WEST SUSSEX COUNTY COUNCIL CONSULTATION

TO:	Arun District Council FAO: Mrs A Gardner
FROM:	WSCC - Highways Authority
DATE:	3 September 2021
LOCATION:	44 Ferringham Lane, Ferring, BN12 5LU
SUBJECT:	FG/145/21/DOC Approval of details reserved by condition imposed under ref FG/115/17/PL relating to Condition Nos 6 - parking spaces, turning facilities & garages, 7 - surface water drainage, 8 - landscaping, 10 - cycle parking, 11 - materials & finishes and 12 - screen walls and/or fences.
DATE OF SITE VISIT:	n/a
RECOMMENDATION:	Advice
S106 CONTRIBUTION TOTAL:	n/a

Condition 6 - parking spaces, turning facilities & garages

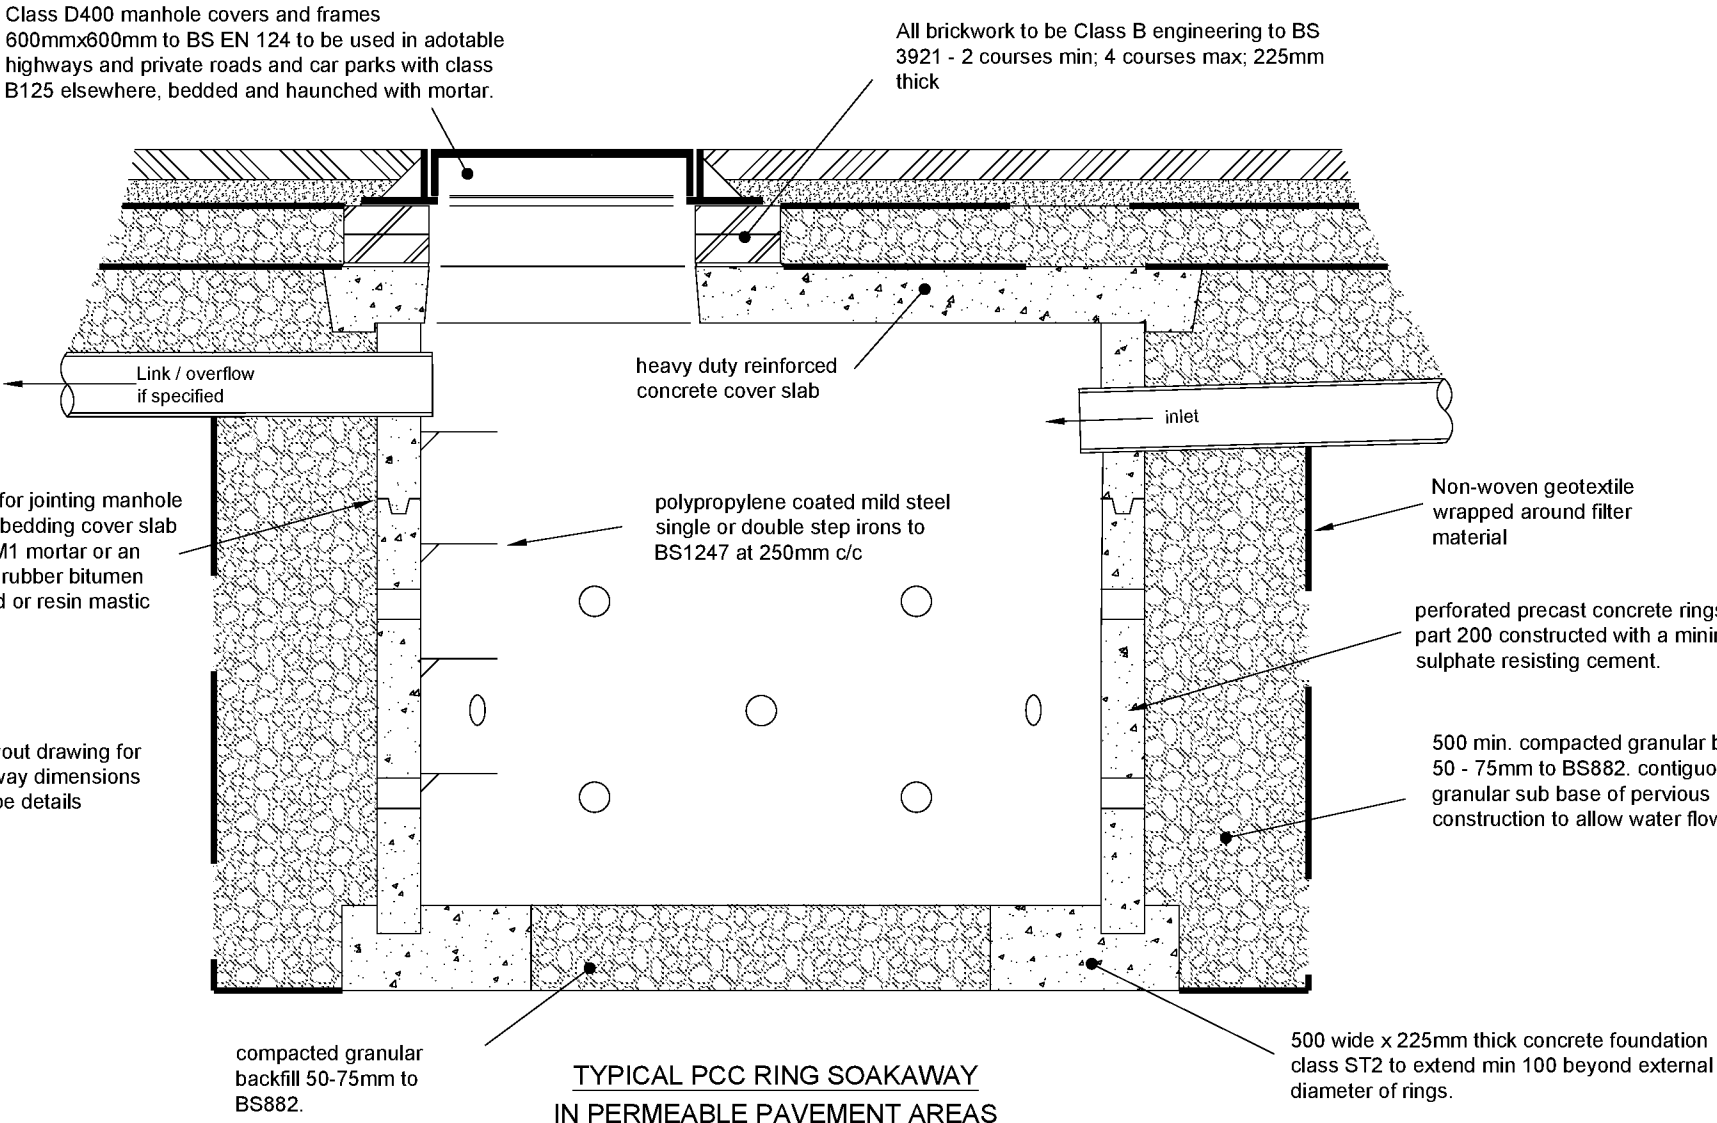
Details of the proposed vehicle parking, turning and garage provision have been demonstrated on plan drawing number 3.17 revision D.

Unit 1 (3 Bed) – 1 Frontage Hardstanding Space + 1 Internal Garage Space
Unit 2 (3 Bed) – 1 Frontage Hardstanding Space + 1 Internal Garage Space
Unit 3 (3 Bed) – 1 Frontage Hardstanding Space + 1 Internal Garage Space
Unit 4 (4 Bed) – 2 Frontage Hardstanding Spaces + 1 Independent Garage Space
Hardstanding 1 Internal Garage Space

An additional 3 'unallocated' visitor car parking spaces will be provided.

While not specifically demonstrated within the submitted plan for this application, floor plans submitted within FG/50/21/PL demonstrated the garages are considered suitably sized. However as per Arun DC's SPD garage spaces only count as 0.5 towards an allocated parking space.

In total while 12 physical spaces in total are being provided, because 4 are garage spaces it is considered that a total of 10 spaces are being provided with plots 1-3 being afforded 1.5 spaces each and plot 4 being afforded 2.5 spaces.

With each plots parking demand considered independently it could be concluded that each dwelling is under provided parking by 0.5 of a space. However, the proposed unallocated visitor parking provision, which is more generous than the Arun SPD requires, makes up for any shortfall in anticipated demand.

The plan demonstrates that the central turning area is of a suitable size and geometry to facilitate the turning of a fire tender.

Plan
Garden Sheds / Cycle store 1:50

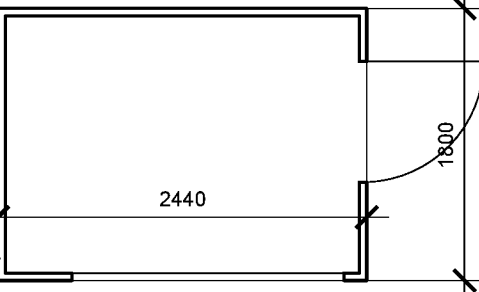
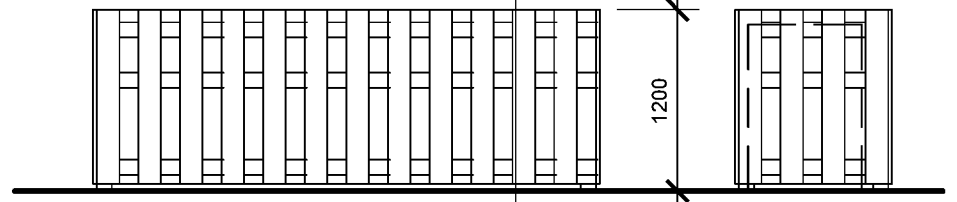
Details of the proposed cycle parking provision have been demonstrated on plan drawing number 3.17 revision D.

Each plot will be provided with an independent 2.44 x 1.80 garden shed to provide cycle parking.

This would be considered acceptable to meet the cycle parking needs of each dwelling.
